**ADC Planning Consultation
Conservation/Design Officer Response**

Application Number	LU/390/17/PL
Address	Littlehampton Covered Market 26-28 Surrey Street Littlehampton BN17 5BG
Description	Demolition of existing building & erection of 1 No. retail unit & 3 No. flats above with associated external works & access. This application may affect the setting of Listed Buildings & the character & appearance of the Littlehampton (River Road) Conservation Area.
Case Officer	<u>Mrs A Gardner</u>
Date	24 th January 2018

Existing Plans & Elevations

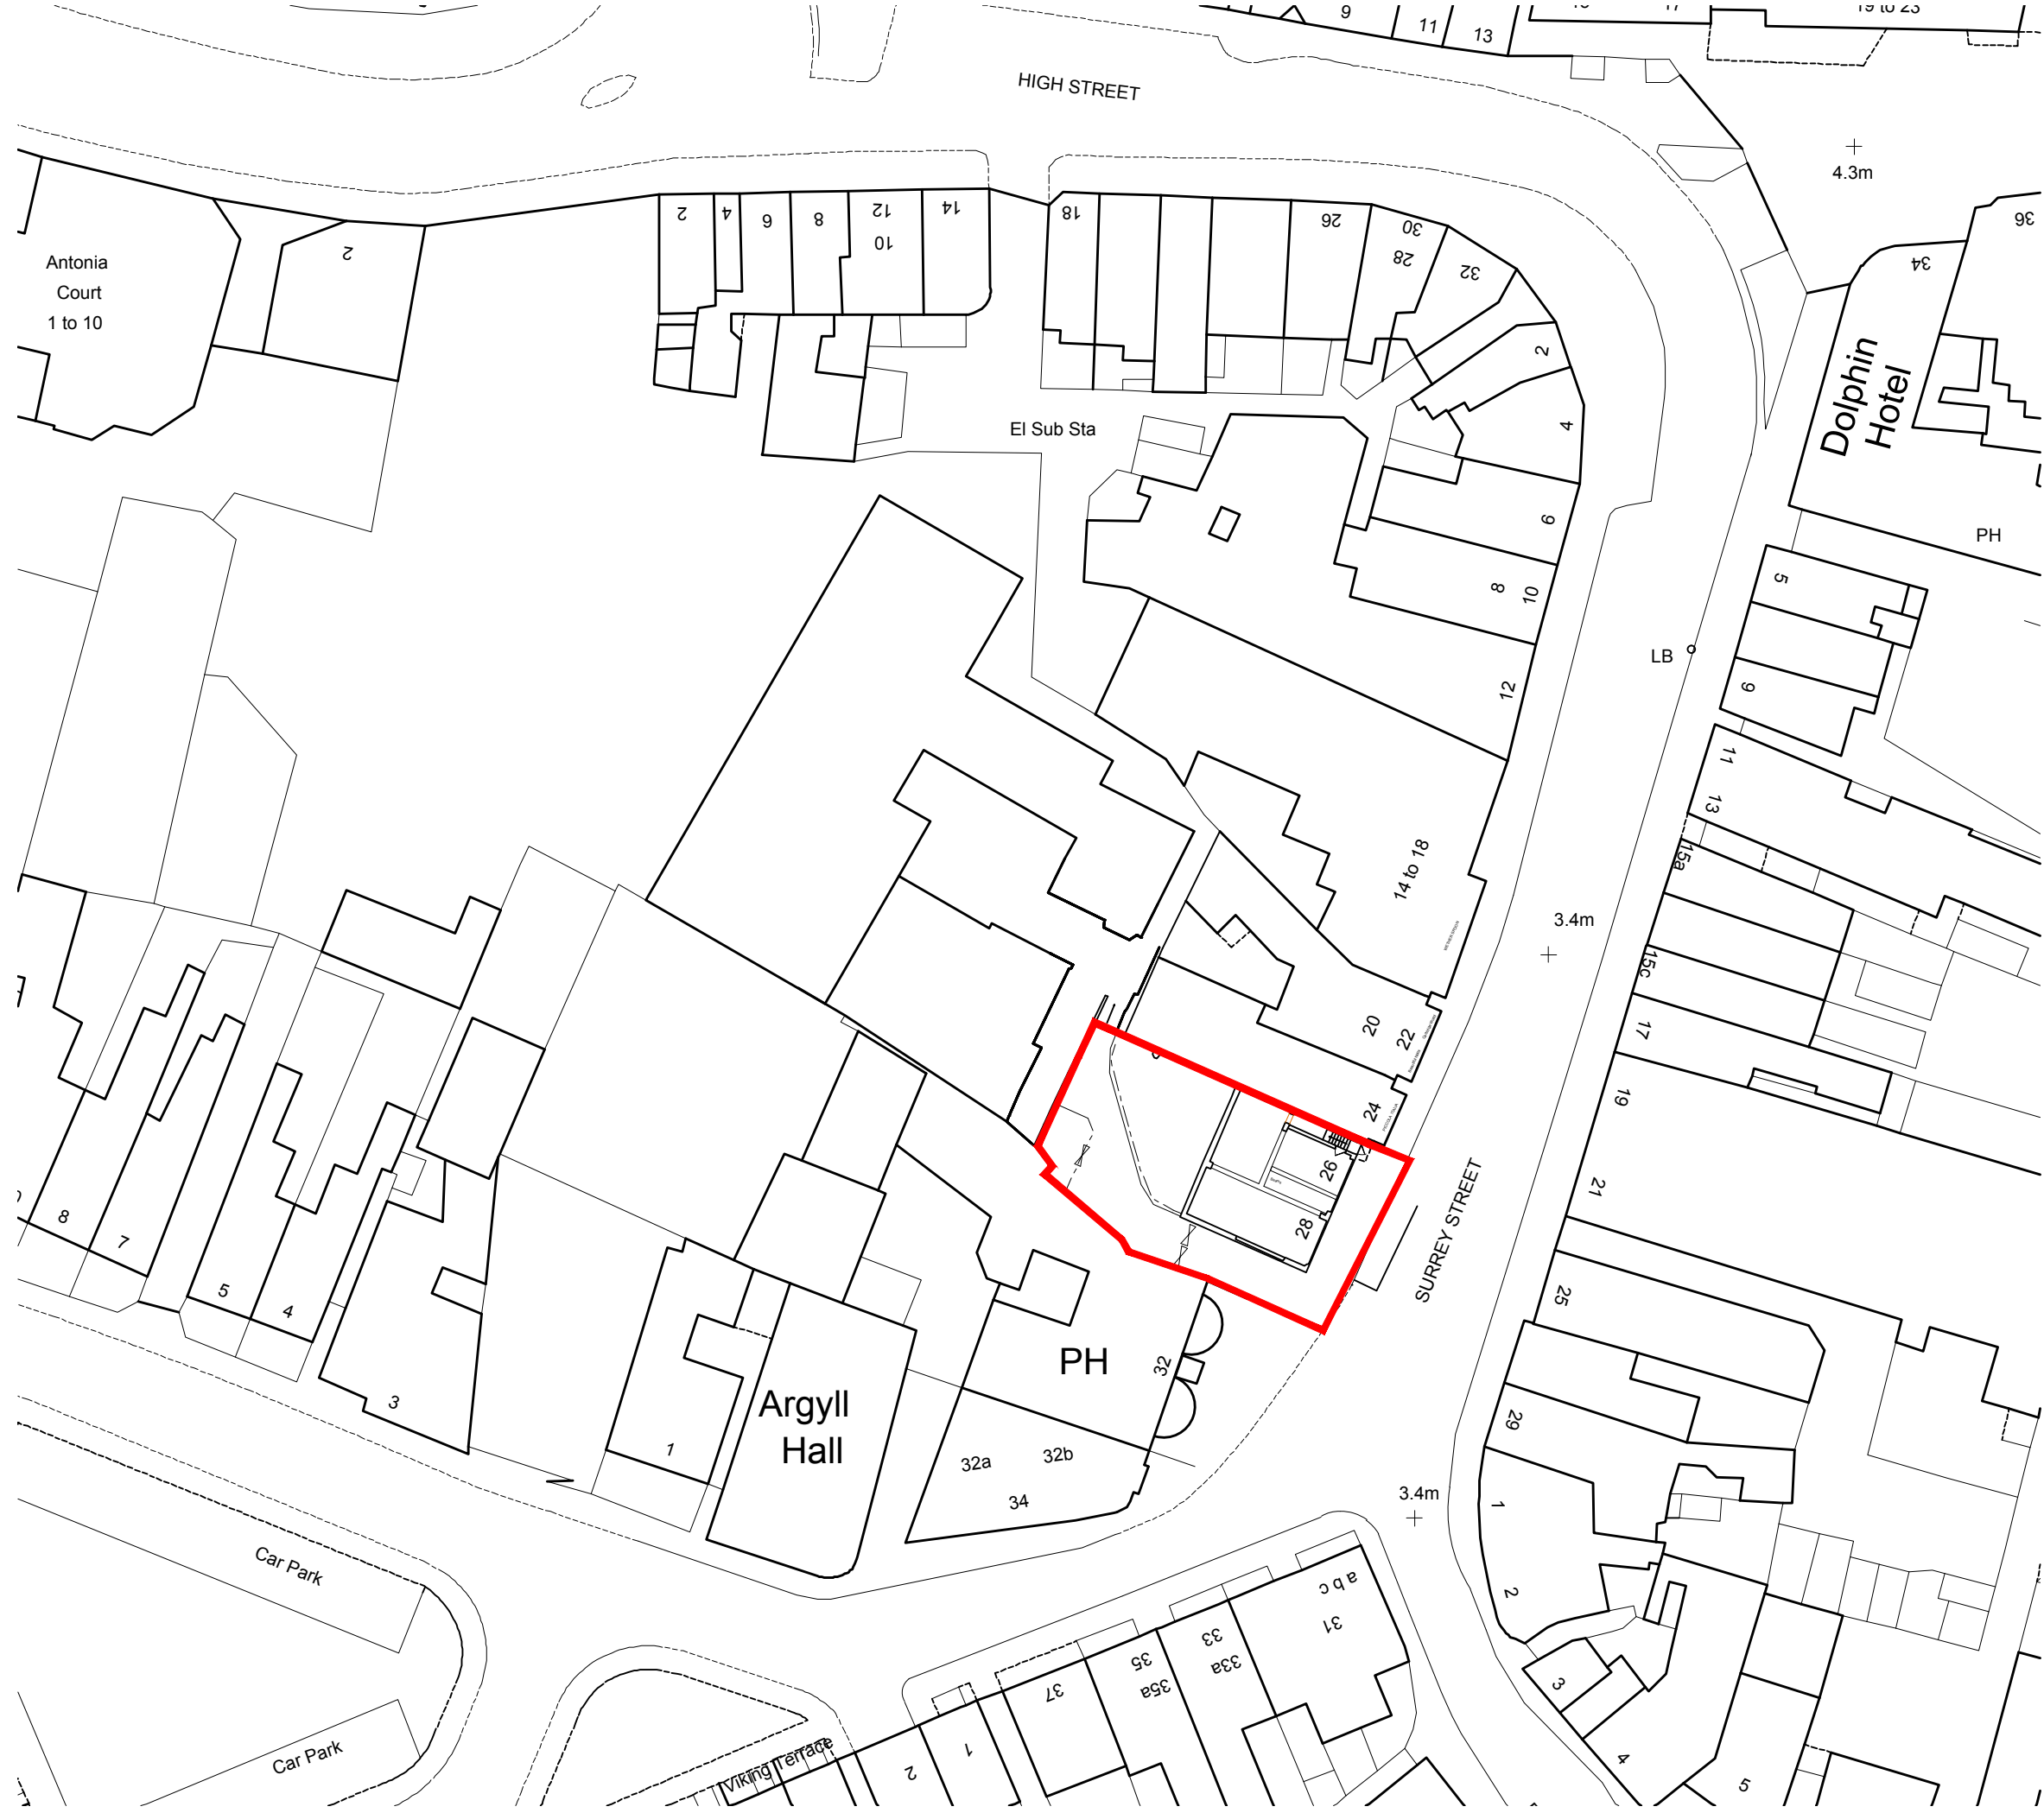
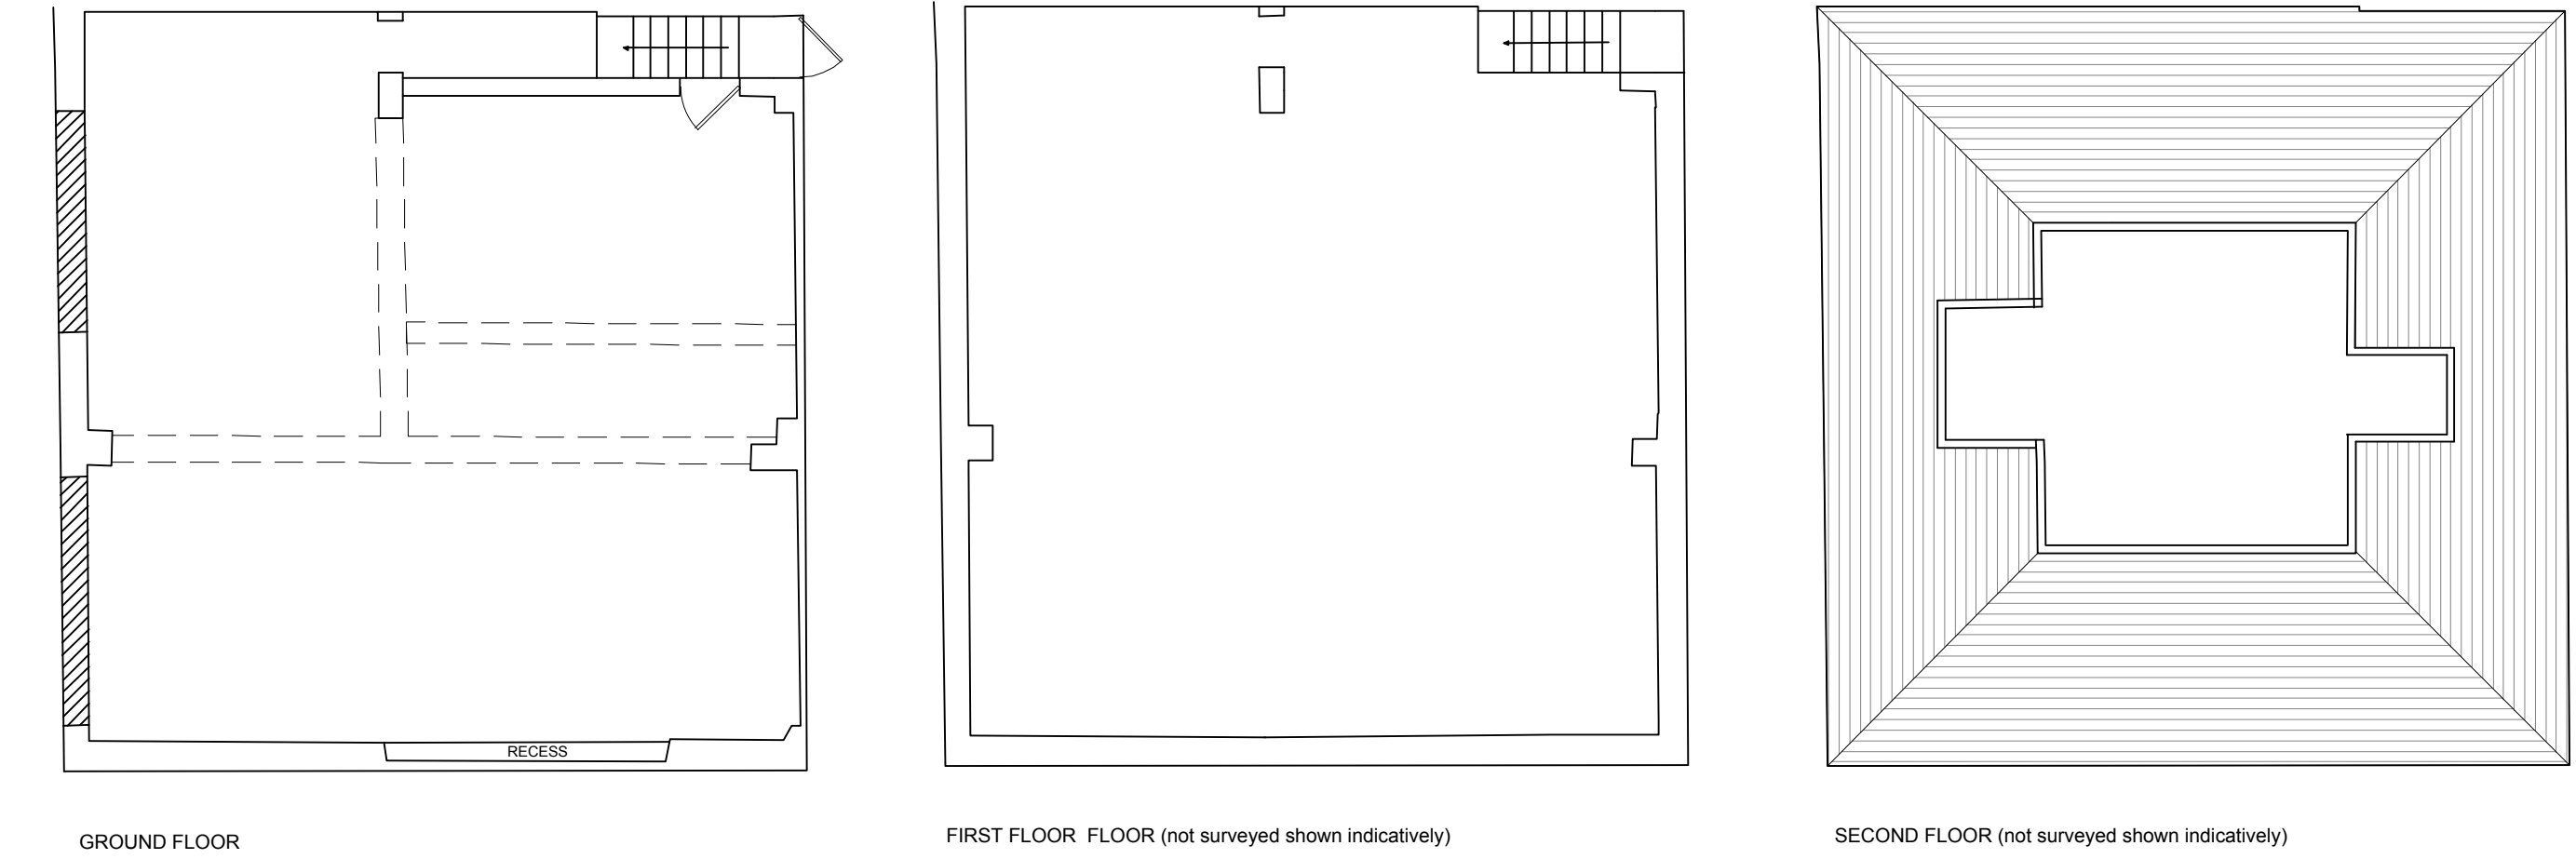
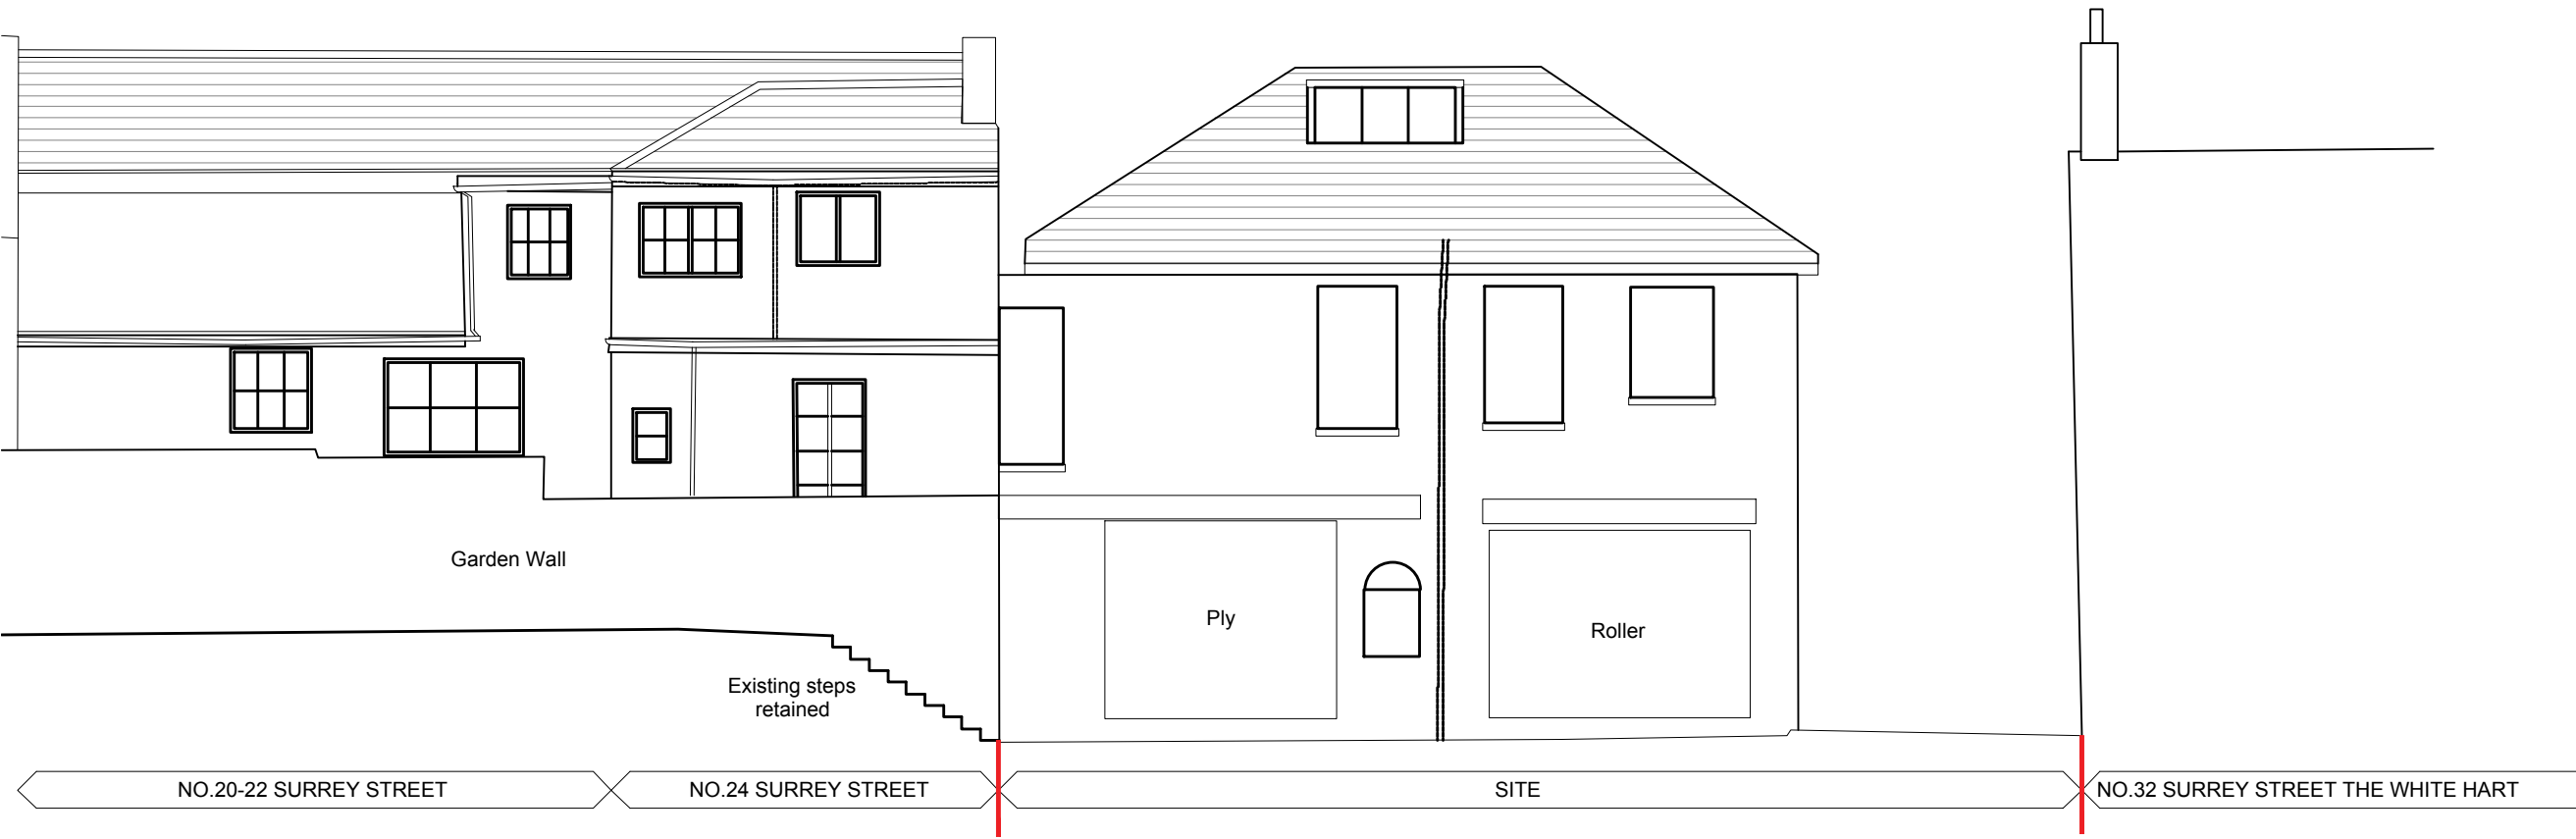
The proposed demolition is regrettable as the existing is a characterful four-square, flint walled structure under a slate roof.
